# CITY OF ALBUQUERQUE

**Re: Drainage Report Addendum for La Cuentista II  
Engineer's Stamp Date 1-12-15 (D10D002B)**

**Drainage Report  
ADDENDUM  
for  
LA CUENTISTA  
SUBDIVISION, UNIT II**

**Re: Drainage Report Addendum for La Cuentista II  
Engineer's Stamp Date 12-30-14 (D10D002B)**

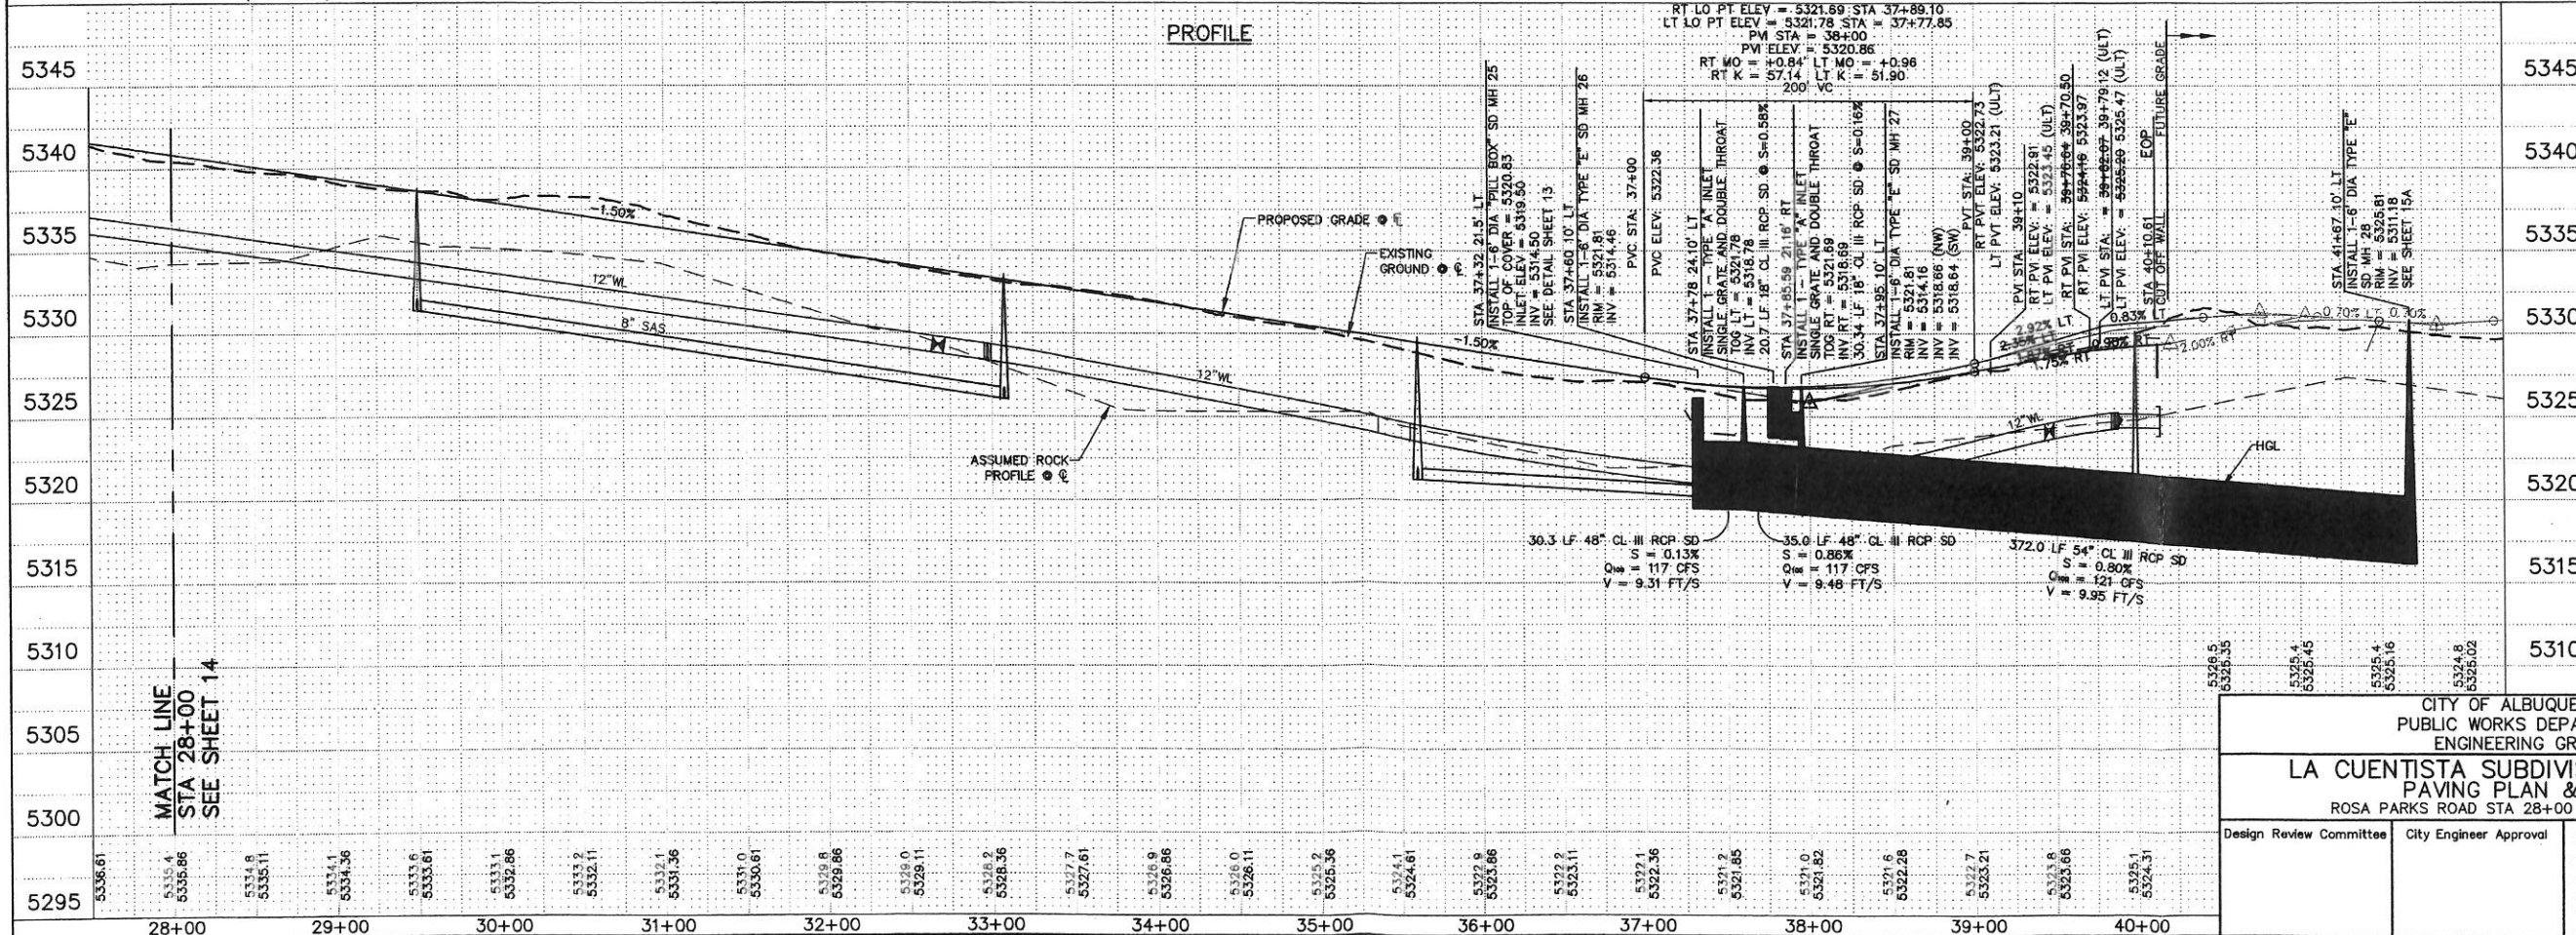
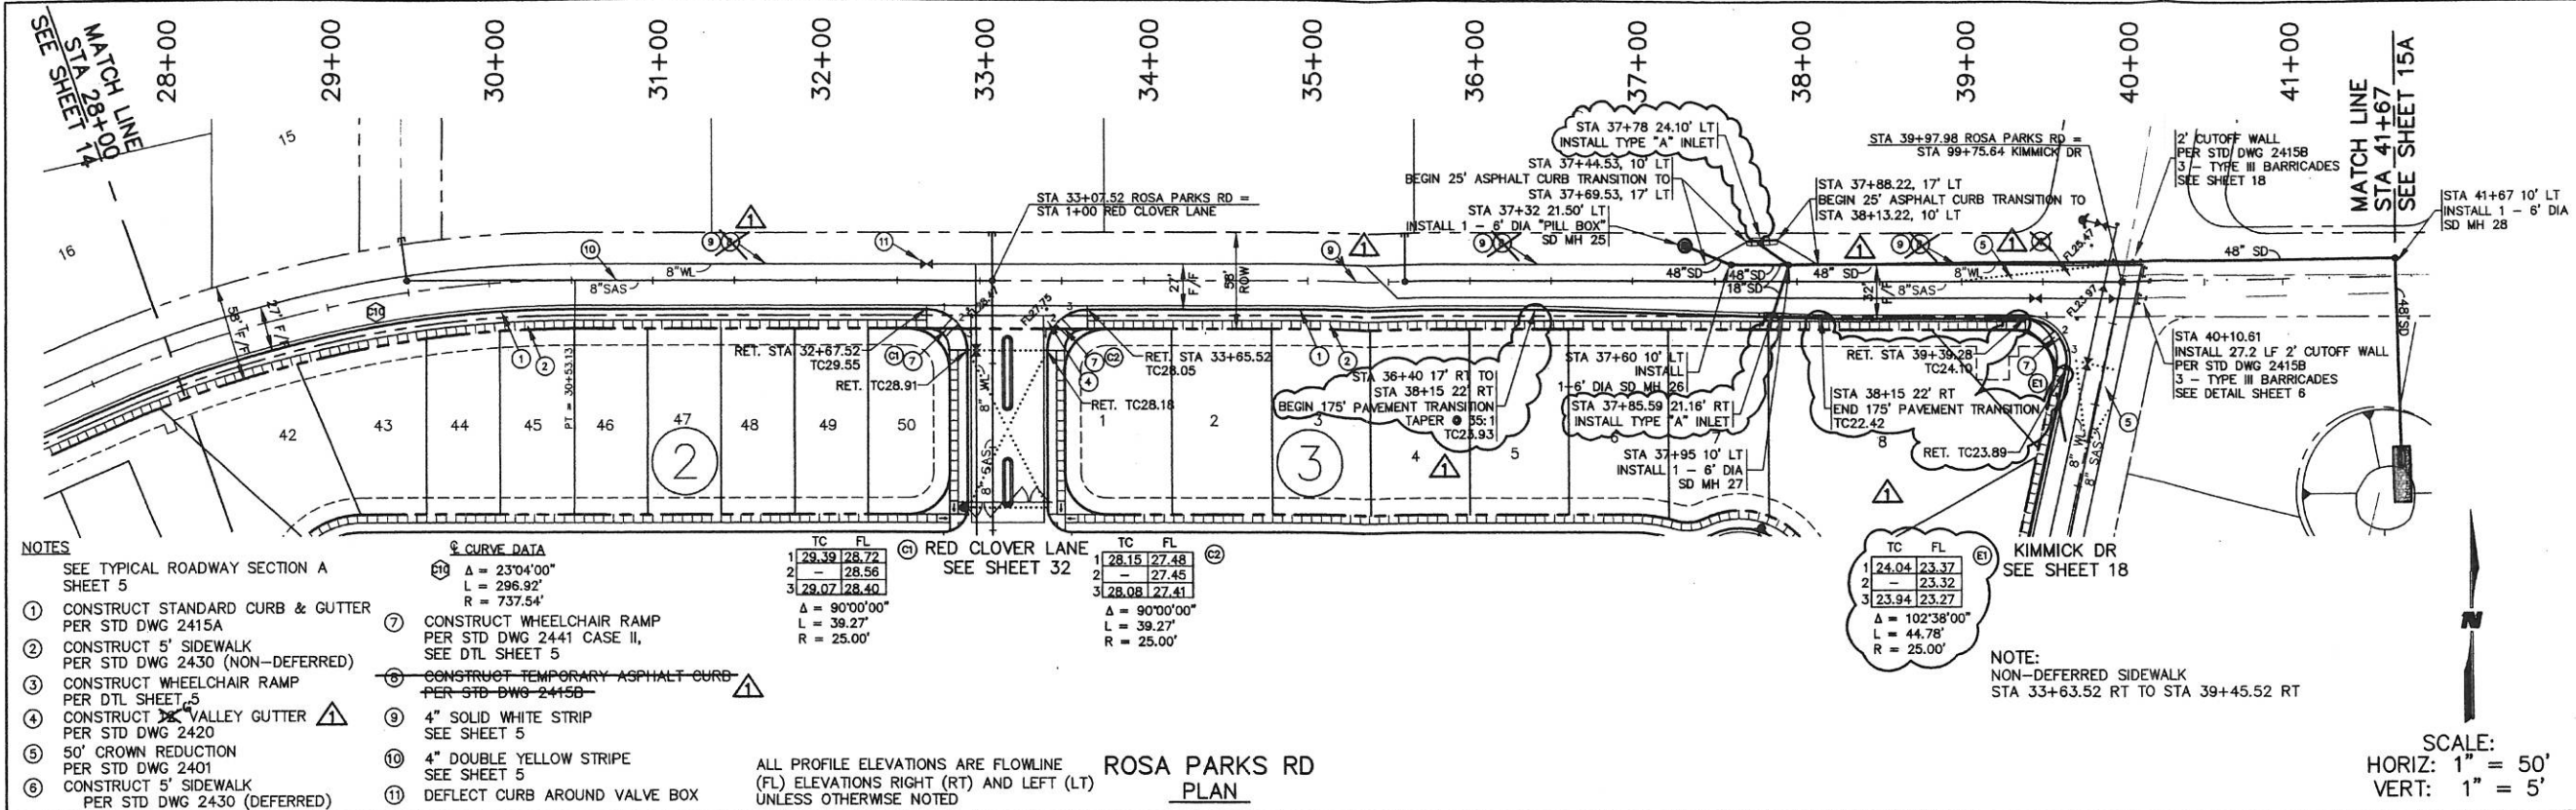
5. It appears the last sheet in the report (sheet 15 of 37) may have been mislabeled as with AP-3. Isn't this sheet applicable to AP-4?

AR2

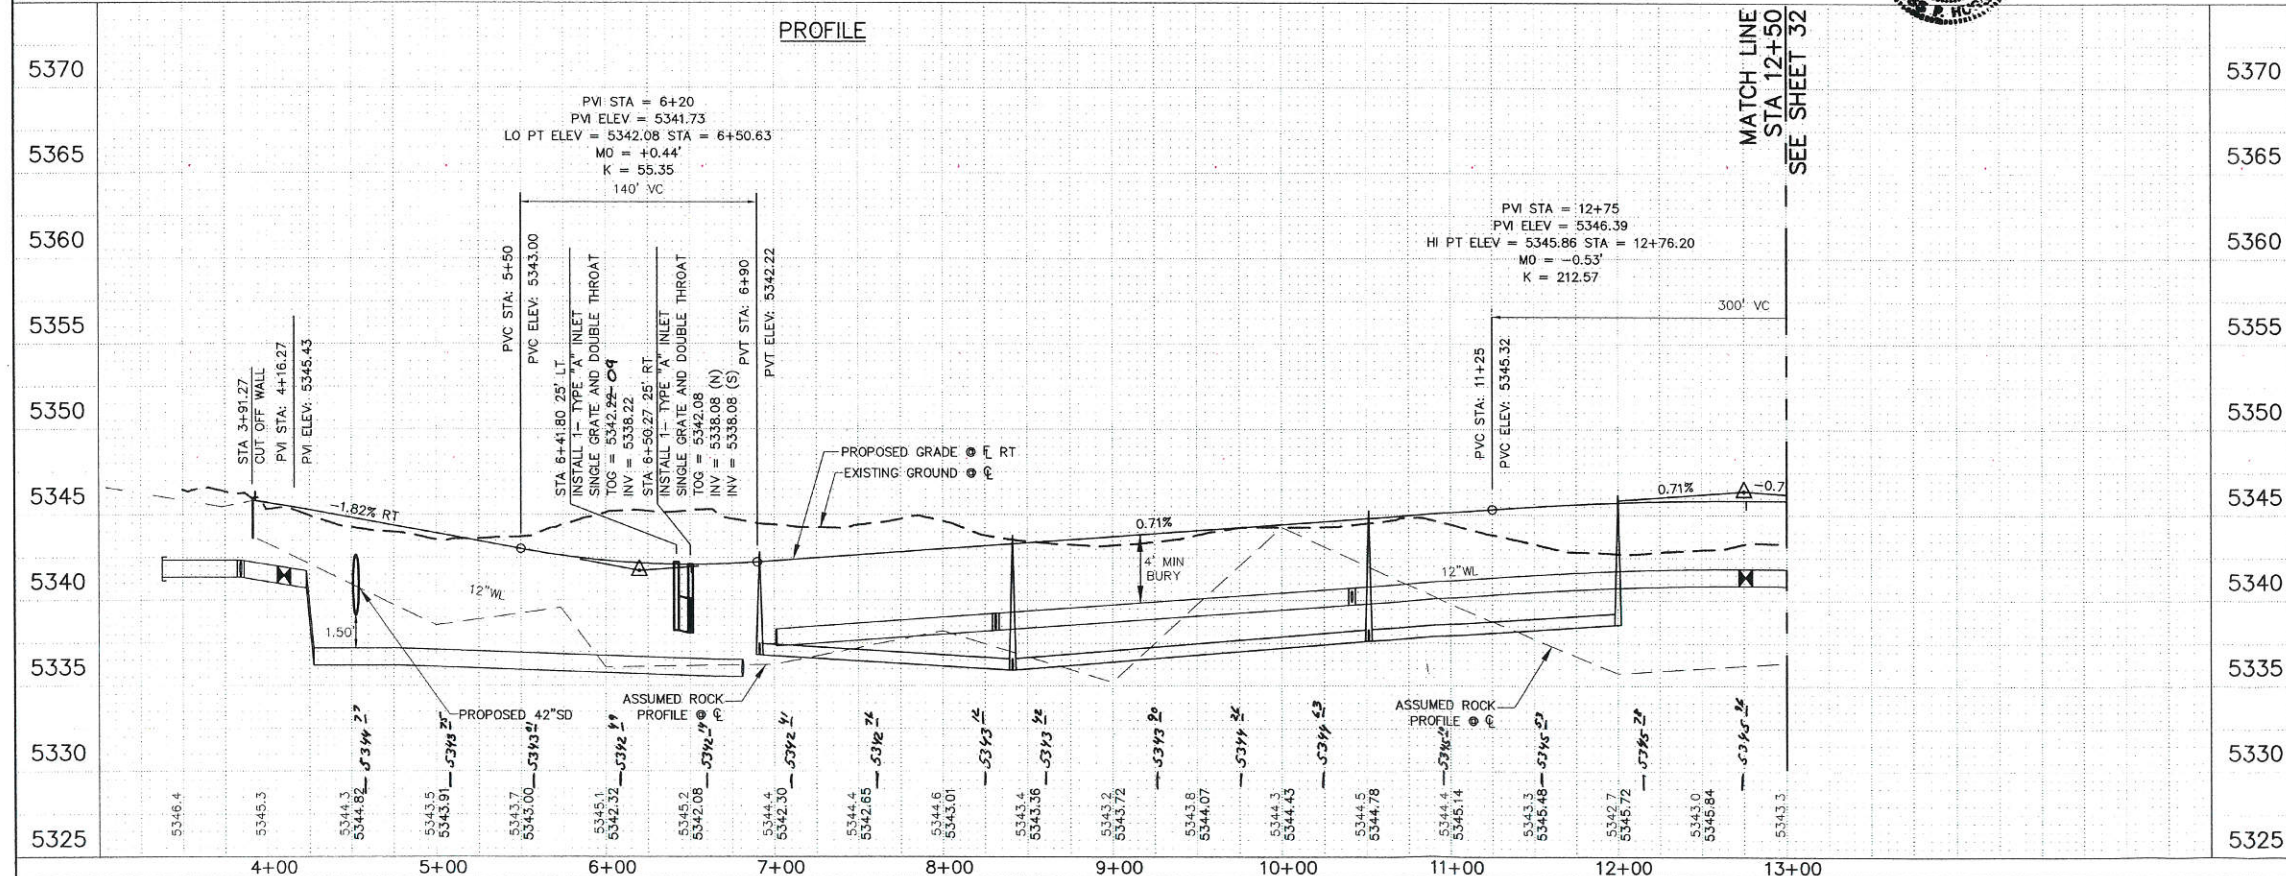
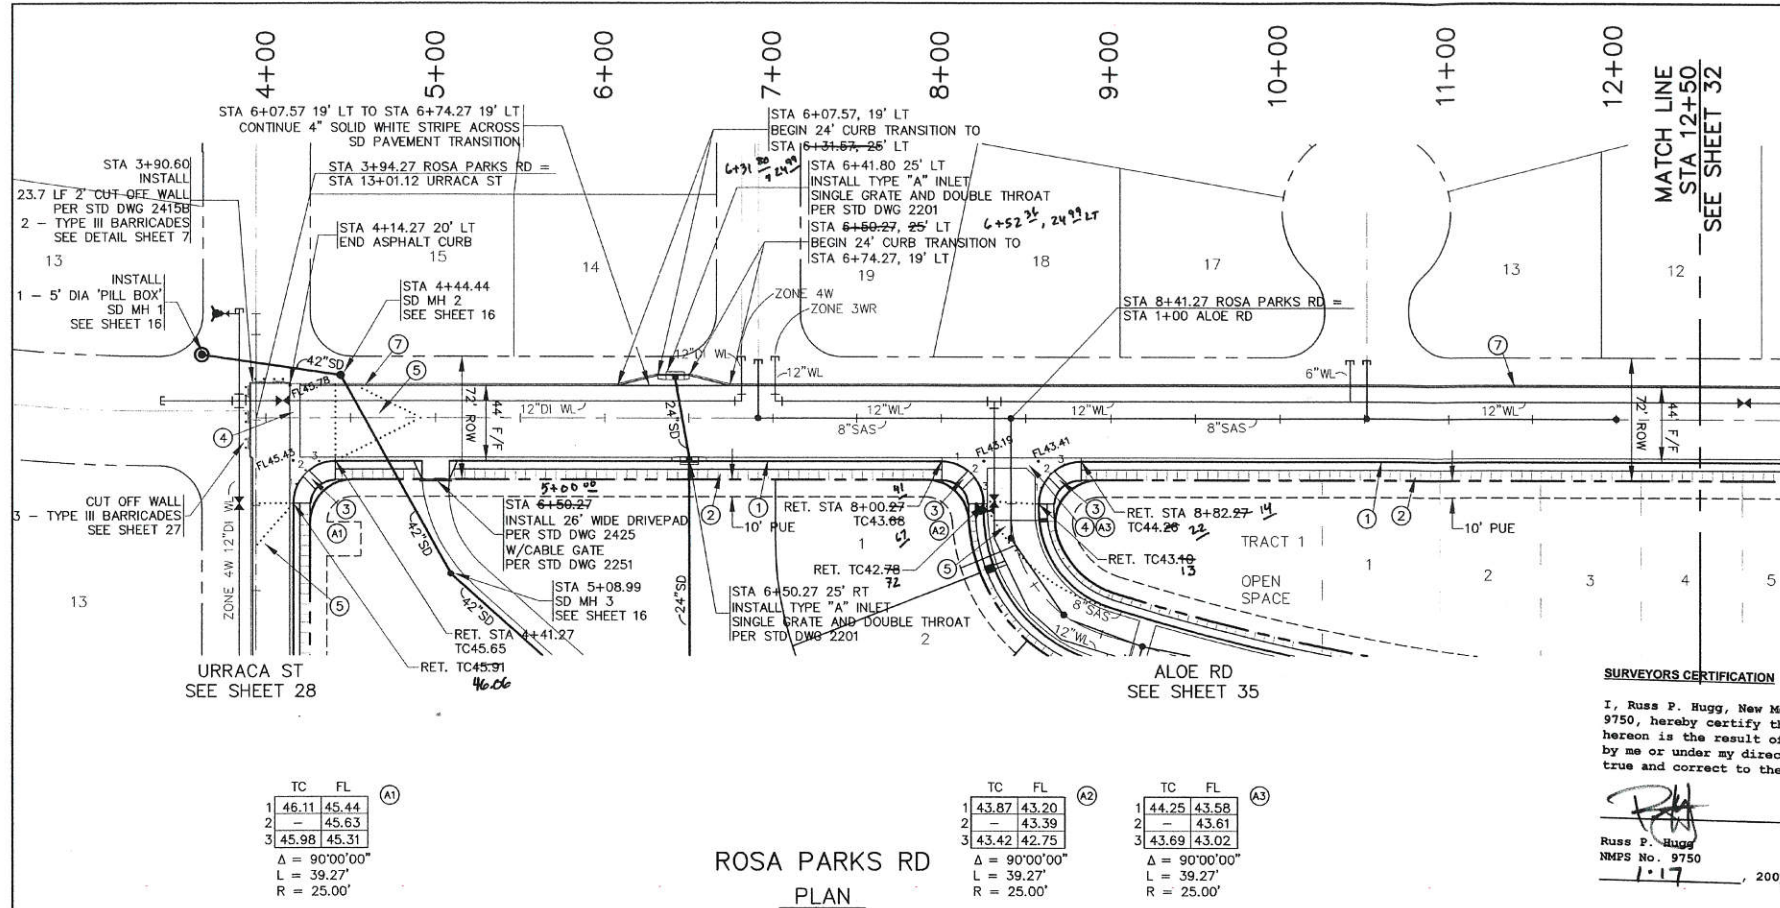
4. On the "Combination Inlet in Sag" calculation sheet; why was 21.35 cfs used when it appears the flow reaching these inlet is 32 cfs? Why is it labeled AP2 and AP3 when it receives stormwater from basin OS-7 (AP-3)?

3. AP3 is the flow discharging to Rosa Parks Road with conveyance to the storm drain system to be constructed with Unit II. The capacity calculation for each inlet grate for a typical Type "A" inlet shows 14.5cfs capacity with a 10" depth in a sump condition. This provides 29cfs total capacity for the two inlets in this sag. The existing conditions flow these inlets is approx 30cfs. This location does not meet the criteria for an overflow in the case of clogging in a sump conditions. We propose to reconstruct the two separate Type "A" inlets with a 12' separation to provide the redundant capacity for additional protection. The Calculation and P&P sheet are attached in Tab 8 attached.

We recommend slight modifications to the openings of the pill boxes to receive the full discharge of the offsite basins as proposed. In addition in order to meet the requirements for an inlet in a sump condition as described in the revised DPM we recommend adding a Type A inlet 12 feet from the existing inlet at AP3 to provide redundant capacity. The remaining systems operate as designed.
